WEST SUSSEX COUNTY COUNCIL CONSULTATION

TO:	<u>Arun</u> District Council <u>FAO:</u> Raymond Cole
FROM:	<u>WSCC</u> - Highways Authority: Tim Townsend
DATE:	6th April 2020
LOCATION:	Land North of <u>Sefter</u> Road & 80 Rose Green Road Pagham
SUBJECT:	<u>P/24/20/RES</u> Approval of Reserved Matters pursuant to <u>condition</u> 1 (Reserved Matters details), condition 6 (Design Code Masterplan) and condition 7 (landscaping and layout details) following the approval of Outline planning permission P/134/16/OUT for the erection of 280 dwellings, (including affordable homes), replacement scout hut & Ambulance Community Response Post Facility; provision of a primary vehicular access from Sefter Road; demolition of No. 80 Rose Green Road & creation of a pedestrian & emergency only access; provision of Public Open Spaces including associated children's play areas, landscaping, drainage & earthworks. This application also lies within the parish of Aldwick. This site falls within the Pagham North SD2, CIL Zone 1 (Zero Rated).

This is the WSCC County Highway Authority (CHA) response to the above planning application for approval of Reserved Matters pursuant to condition 1 (Reserved Matters d

FIGURE 5.9: PERMEABILITY PLAN ⓘ

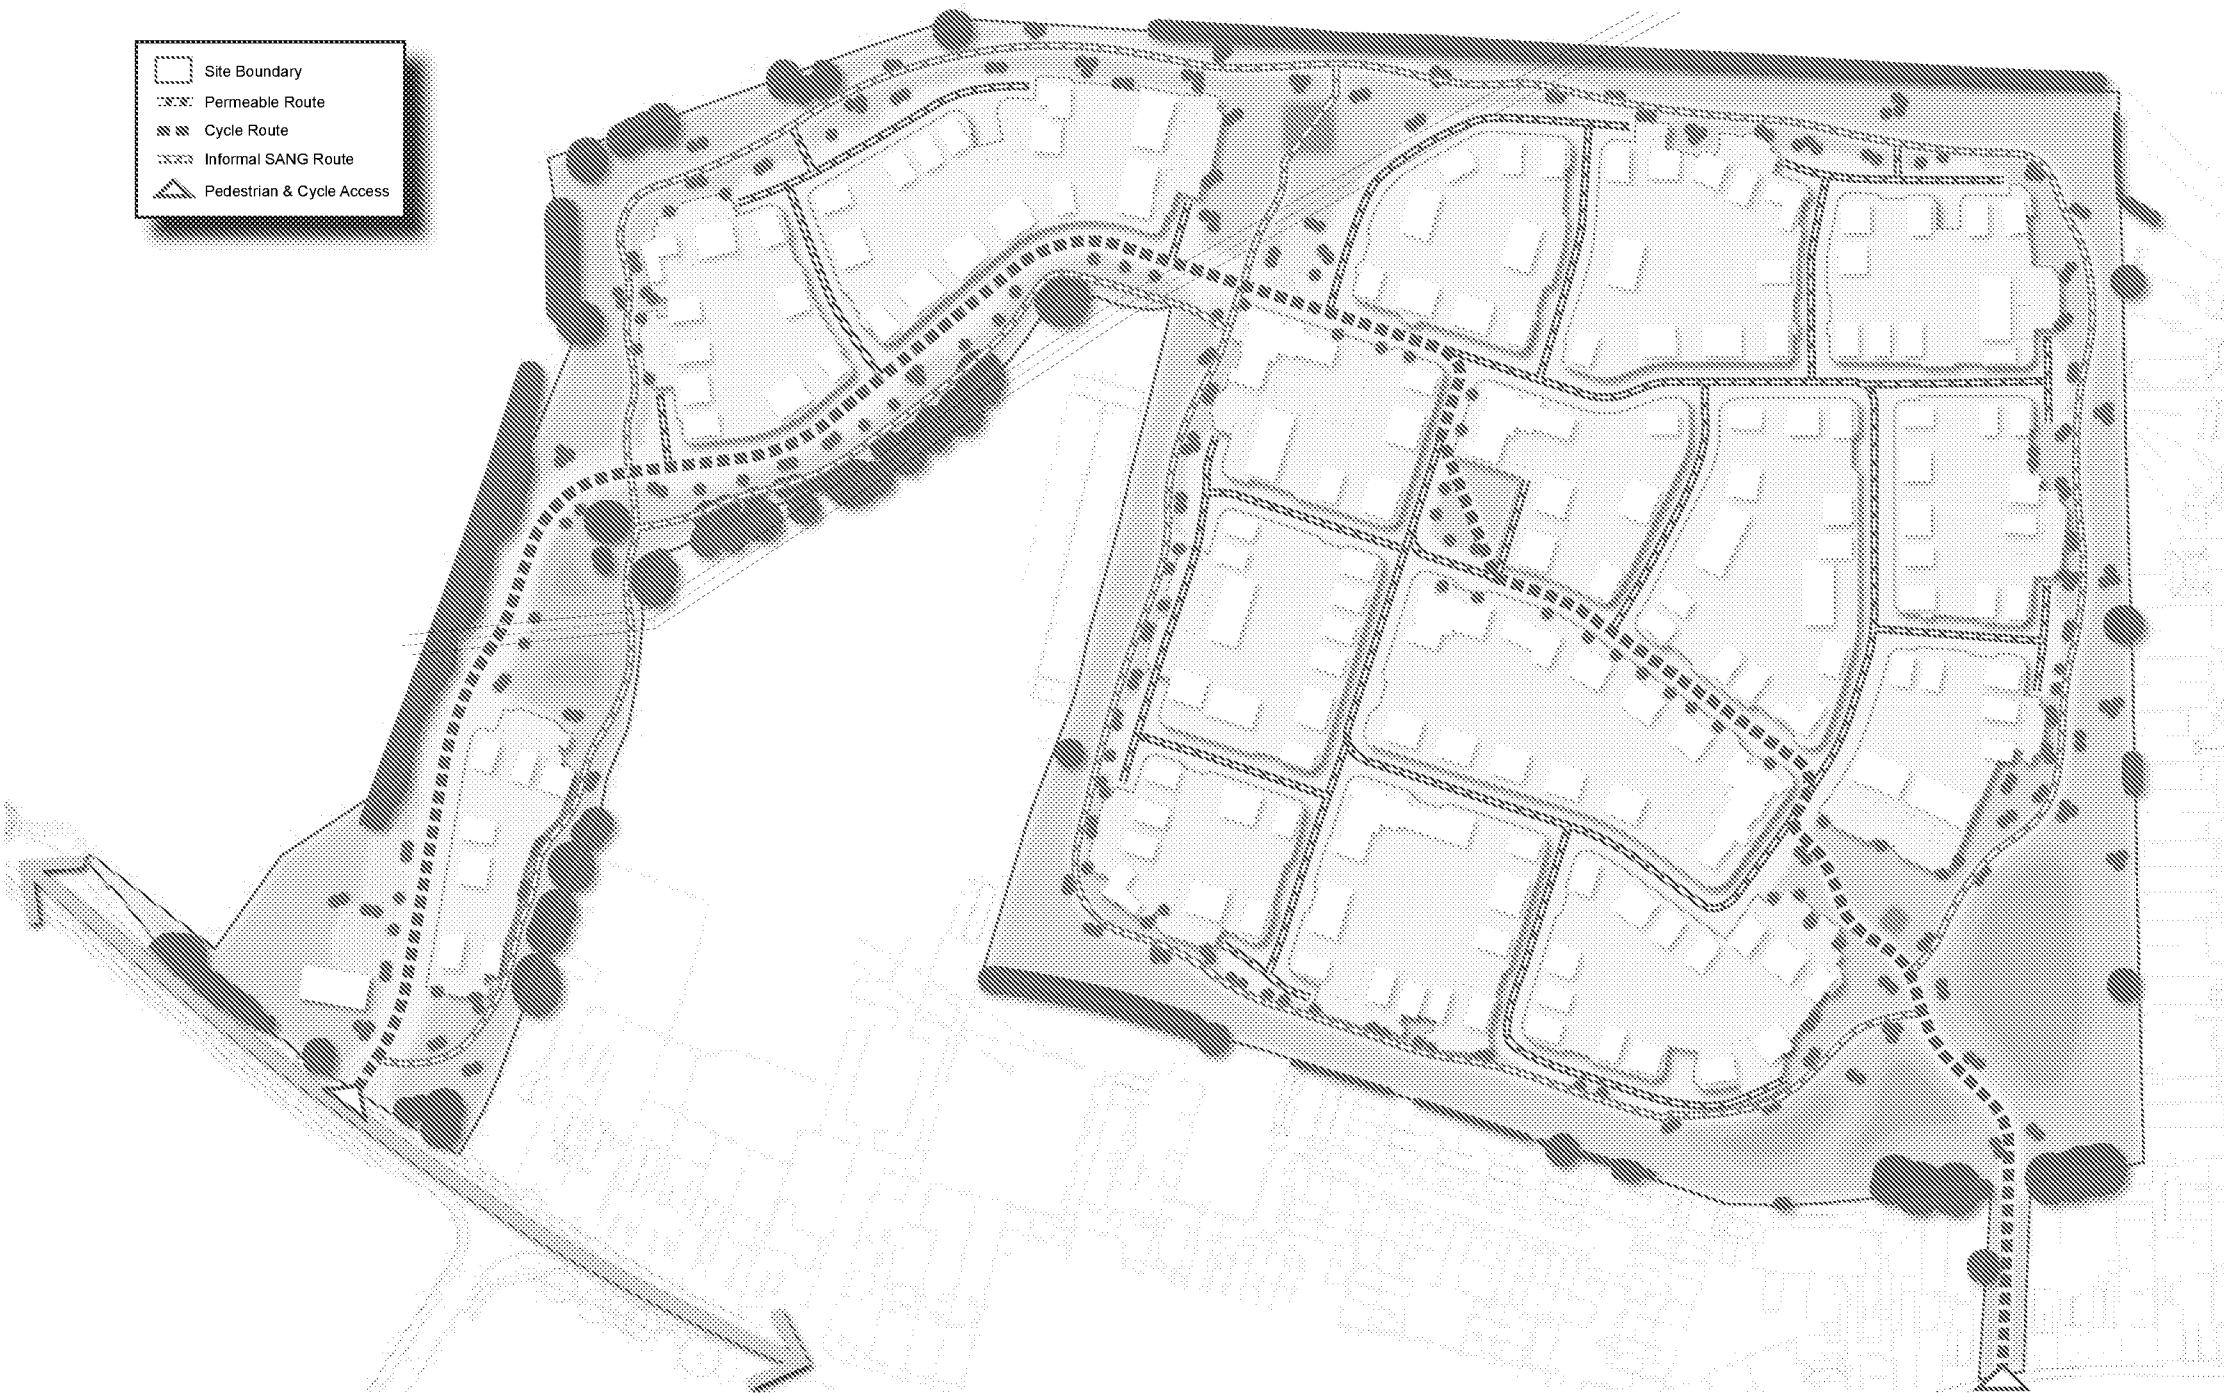
Cycling routes – a 3.0m wide off-road shared footway/cycleway is shown starting at the junction with Sefter Road. It then travels north alongside the carriageway but requires users to cross the spine road from east to west to then continue north-east into the site (although this might be considered confusing to some users and will depend on visibility splays for users – and forward visibility for car drivers – being provided). The route then carries-on eastwards into the main part of the development where it invites users to cross southwards and onto another section generally travelling south-east to link-up with the emergency access to Rose Green Road (this latter section measuring 3.7m wide to cater for emergency vehicles). Also see comments below under *walking routes*.

From scrutiny of the proposed S278 plans for the junction of the new estate road where it meets Sefter Road, no shared footway/cycleway is shown, whereas the plans submitted with this RES application do show this. One possible issue arising here is how cyclists are to enter and leave this off-road route and where – particularly at the Sefter Road end. Also, it is not clear what feature or features

are being provided on or off the carriageway of the spine road to assist with users crossing and interaction with the carriageways at these locations. Further to this, signage or road markings have not been provided and in accordance with the condition, are required at this stage. It needs to be clearly shown how users will interact with one-another at all crossing points (road and foot/cycleways).

Walking routes – Where footways terminate at the start of shared surfaces, they should be carried just beyond any rumble strip feature with pram ramps provided at these points. Some areas within the layout do not show this correctly. With regard to the circulatory walking route around the site, it is recommended that this be widened to permit shared-use by pedestrians and cyclists as this would open-up the rest of the site for more users instead of simply pedestrians. Also, because of the comments found above about the location of the shared footway/cycleway route alongside parts of the internal roadways and the need to cross the road, it is recommended that the designer consider the widened circulatory route as an alternative and/or complementary shared-use route (albeit retaining some form of route alongside the carriageway itself which may or may not be suitable for cycling) and extending it in places (one example being to the south-side of the spine road opposite plots 251-277) to provide for improved connectivity throughout the internal layout and to minimise the need to cross carriageways, where possible. Some additional connections to this path at various points of the layout should be considered. Details of surfacing required too for all routes, please.

FIGURE 5.10: STREET HIERARCHY PLAN ①

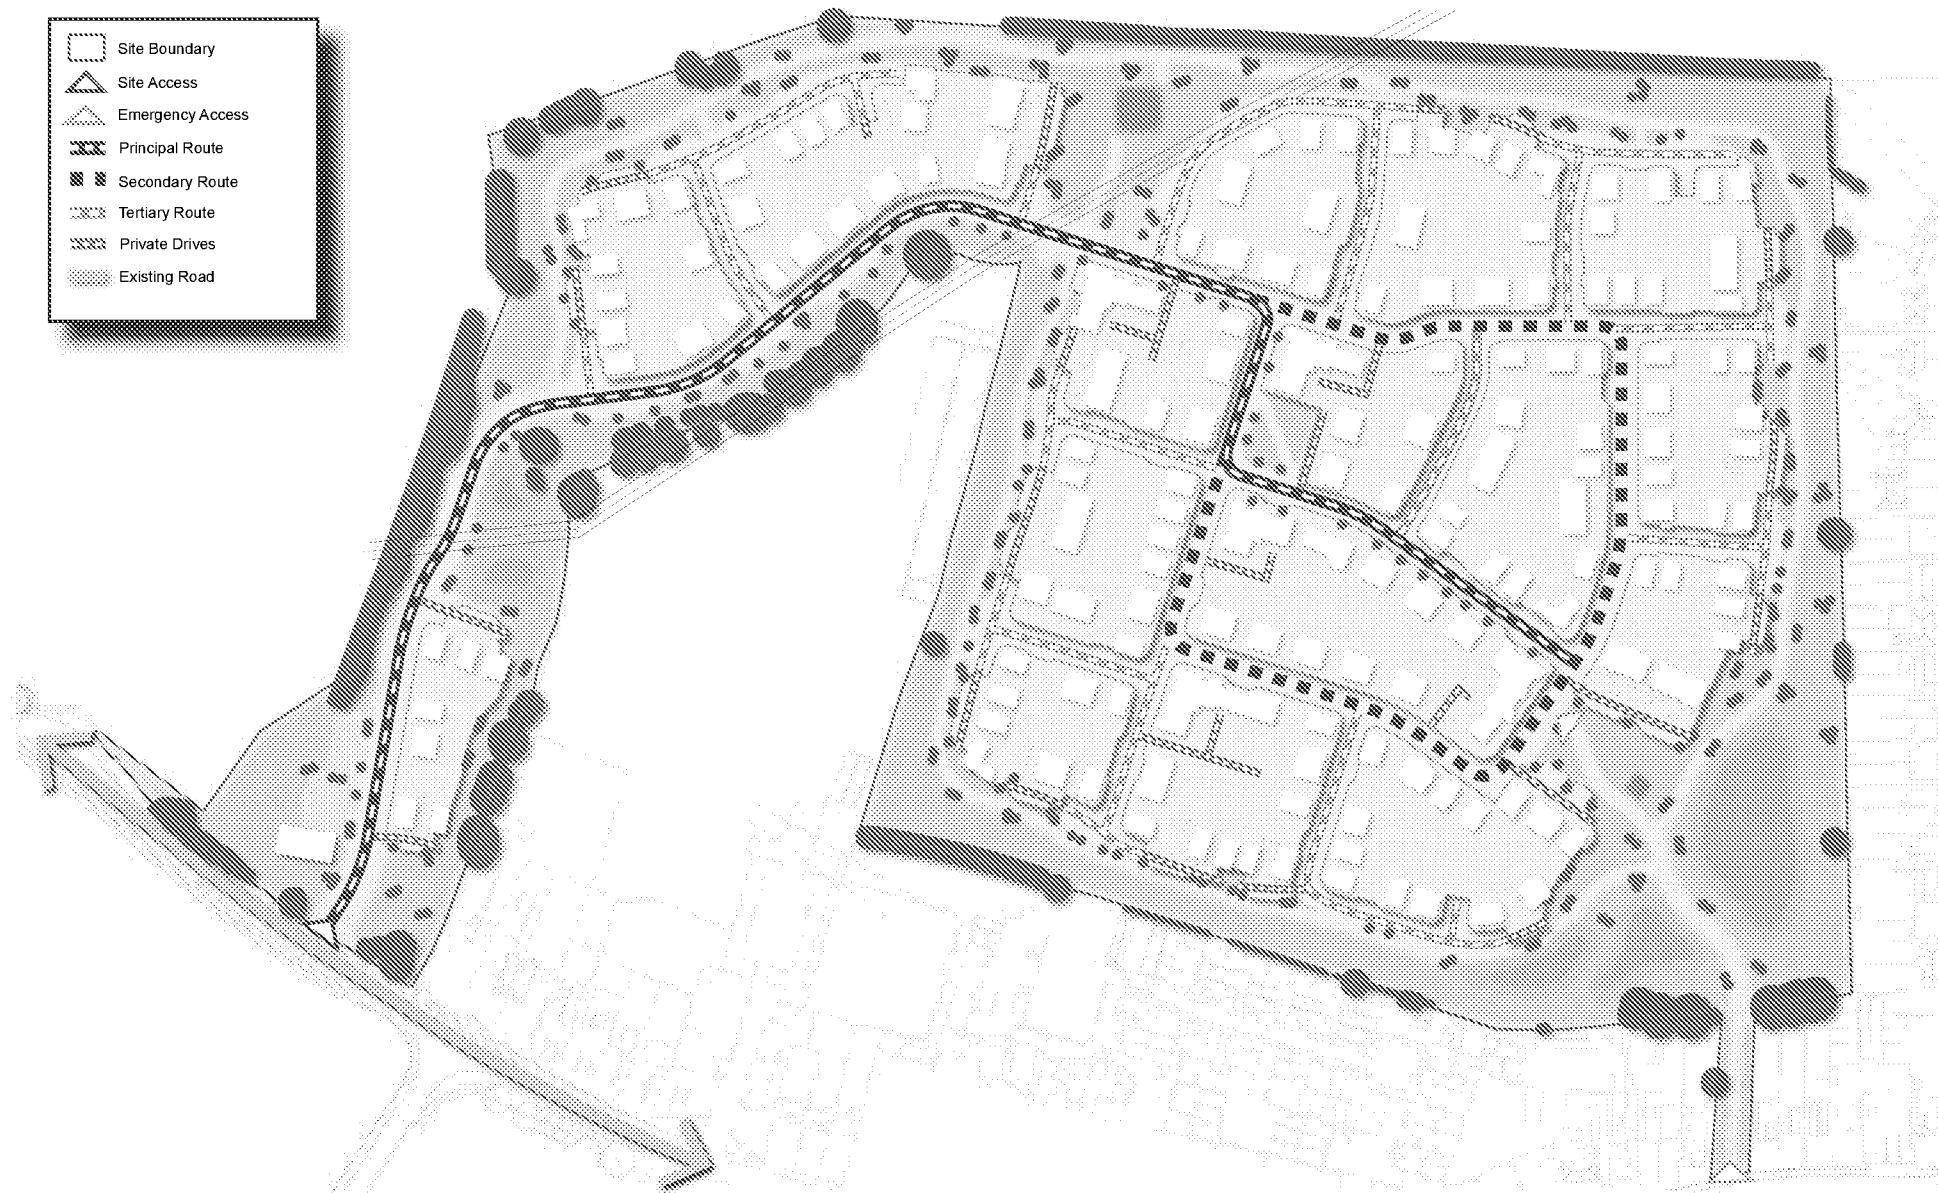
Street hierarchy – While this matter is perhaps more for the LPA to respond to, from a CHA point of view, the layout appears to be made up of sections of traditional carriageway with footways alongside – generally the main spine road and some other roads leading off it – and then a series of shared-surface roads and private drives which are generally located around the periphery of the site. Additional to this, a walkway is provided around the whole site (annotated as ‘circulatory walkway’ on the submitted drawings) and a 3.0m wide shared footway/cycleway is shown alongside parts of the spine road and other internal roads, then leading to a predominantly off-road section where it links to Rose Green Road along the emergency access route (south-eastern part of the site) measuring 3.7m wide at this point. Further comments will be made under Condition 7 (landscaping and layout), below.

3. Condition 7 (landscaping and layout details) – As documented above in point 2 (condition 6), the internal road network is shown made-up of a combination traditional roads with footways running alongside (mainly the internal spine road and some of the roads leading off it) with others shown as either shared-surface roads or private driveways. Carriageway widths range from 4.8m wide (for the lesser/shared surface routes) to 5.5m wide for the main spine road.
